**Tamworth Solar Farm (SSD-9264)  
Request for Additional Information**

I refer to the assessment of Tamworth Solar Farm (SSD-9264). After careful consideration, the Department is requesting that you provide additional information.

Figure 2. Site entrance points.

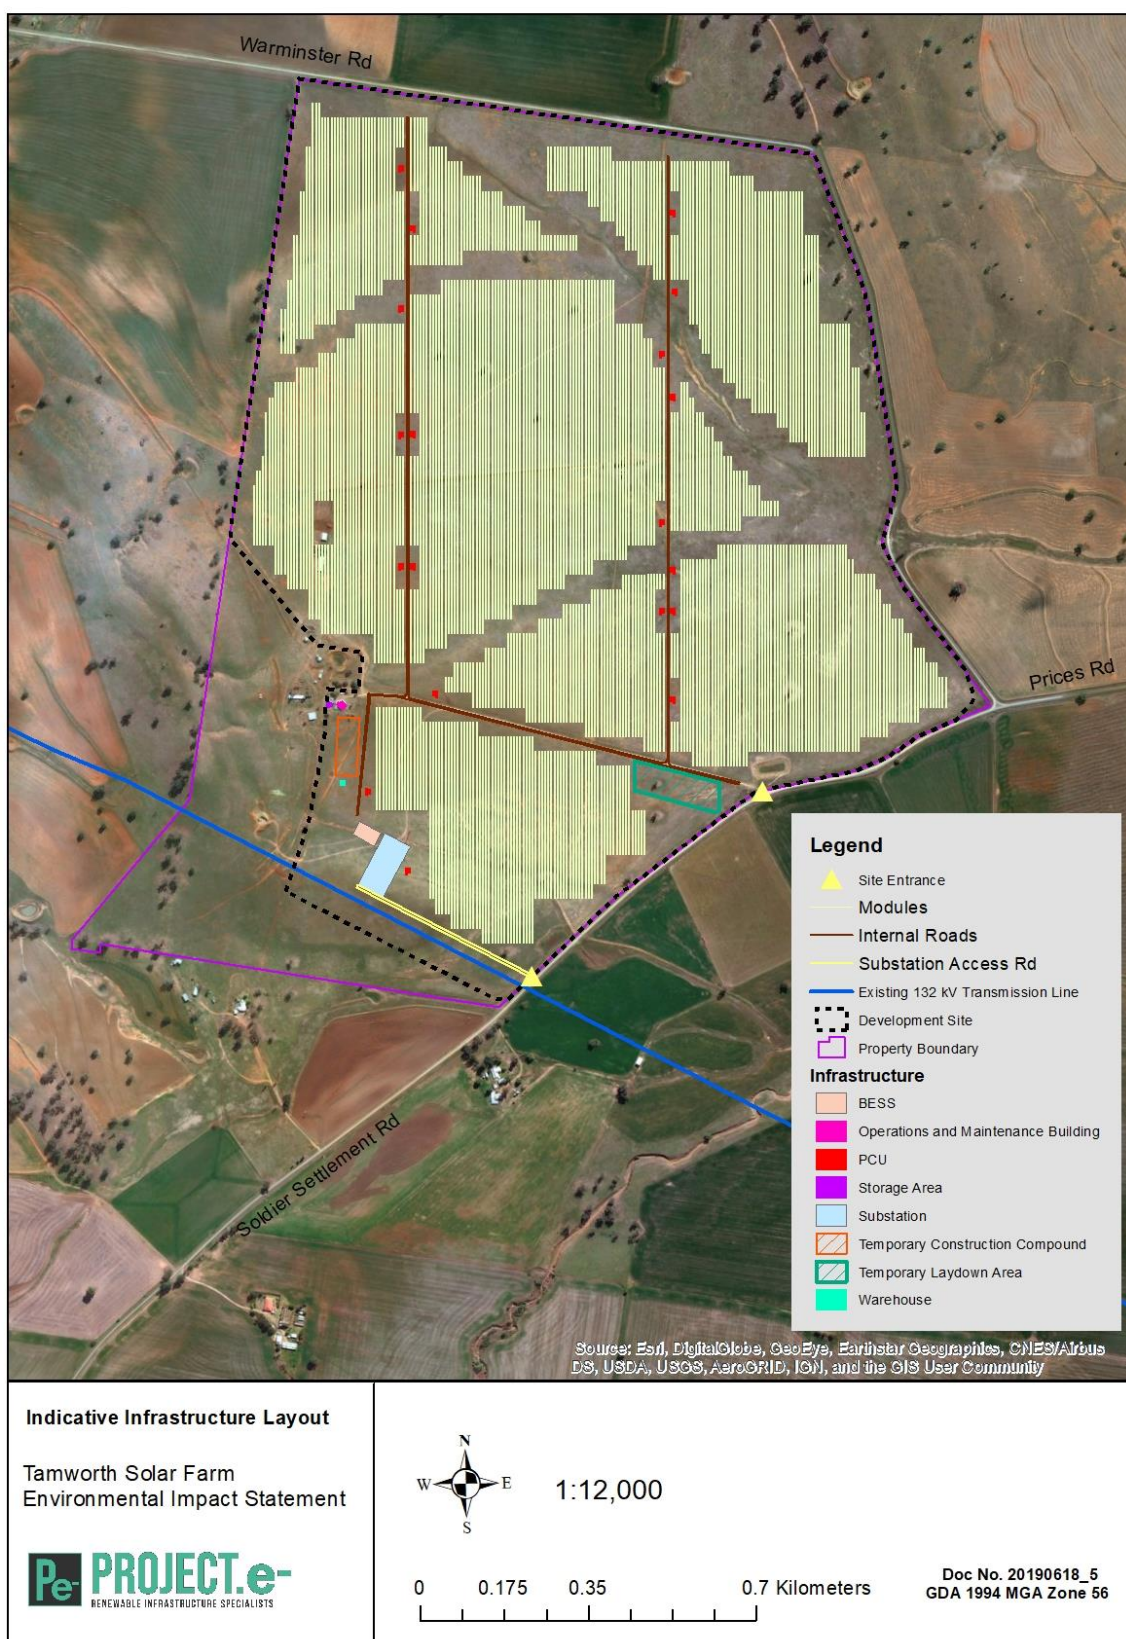
- **Traffic and transport:**
  - clarify the number and location of site access points to the site;
  - clarify the impact on school bus routes near the intersection of Oxley Highway and Babbins Road and evidence of consultation with operators.

PROPOSED INTERSECTION

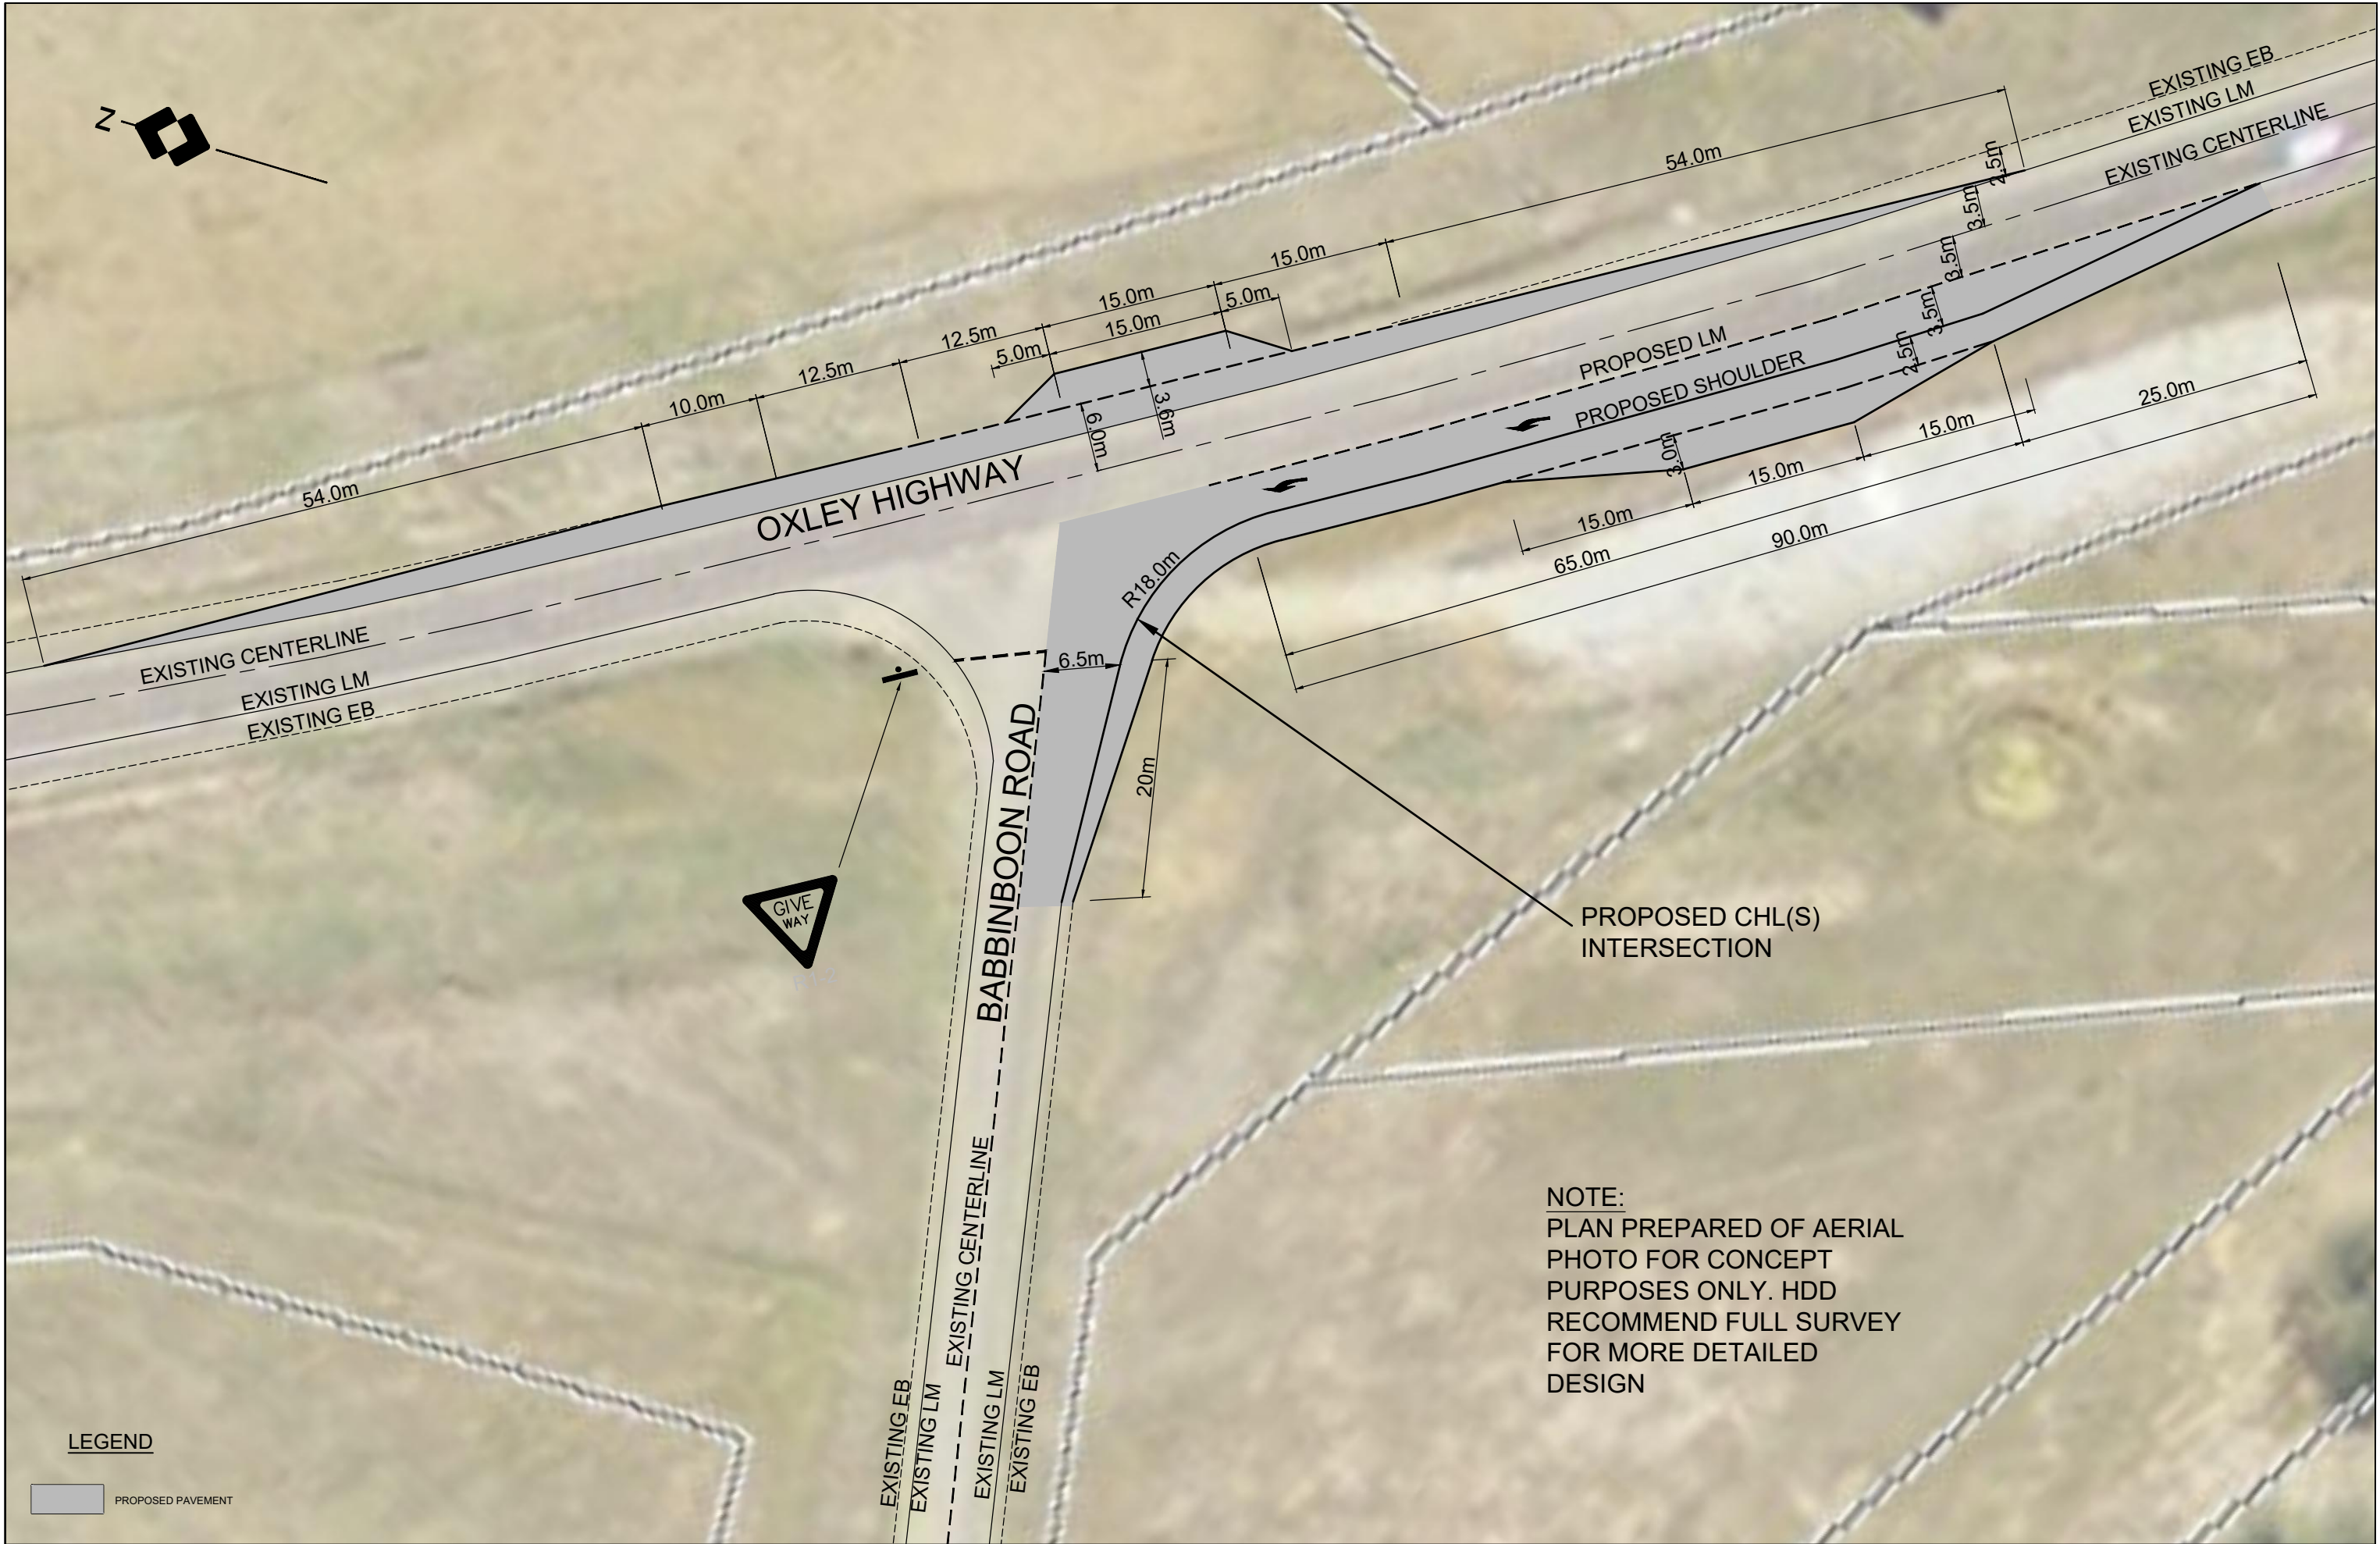
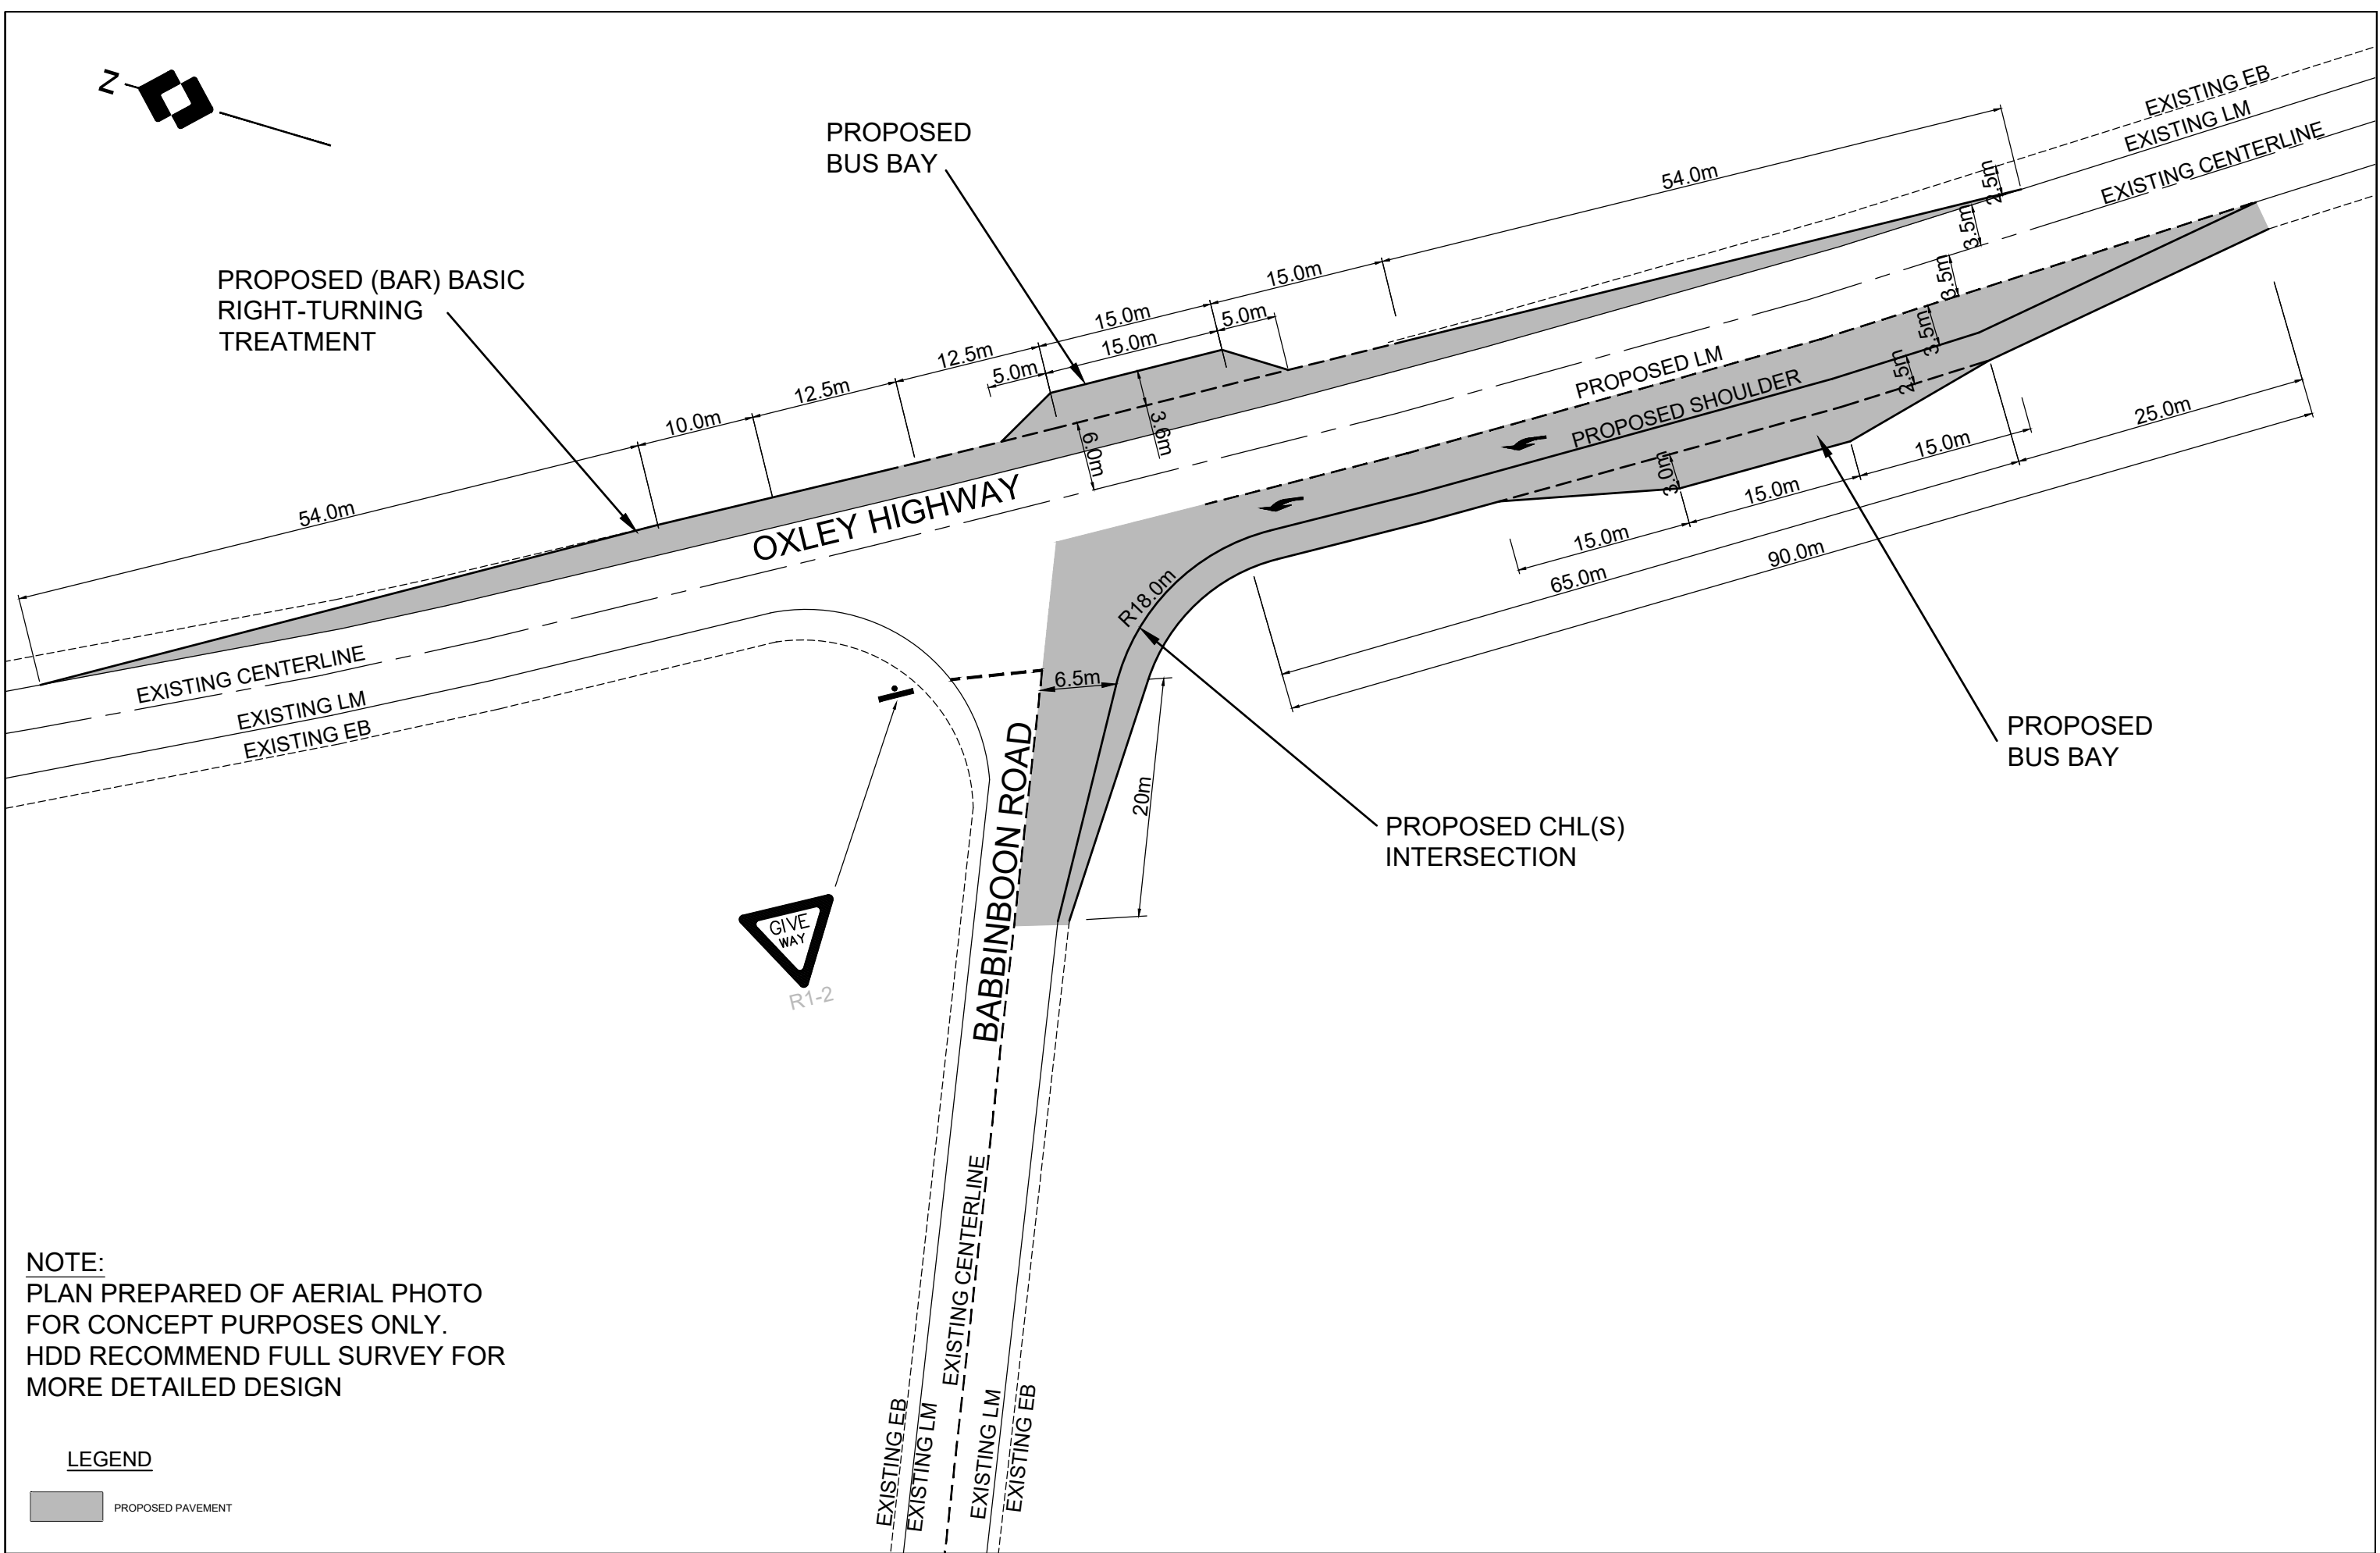
- **Road upgrades:**
  - clarify the nature and location(s) of the intersection upgrades and intersection treatment types and include a swept path diagram for the largest vehicles travelling to and from the site;
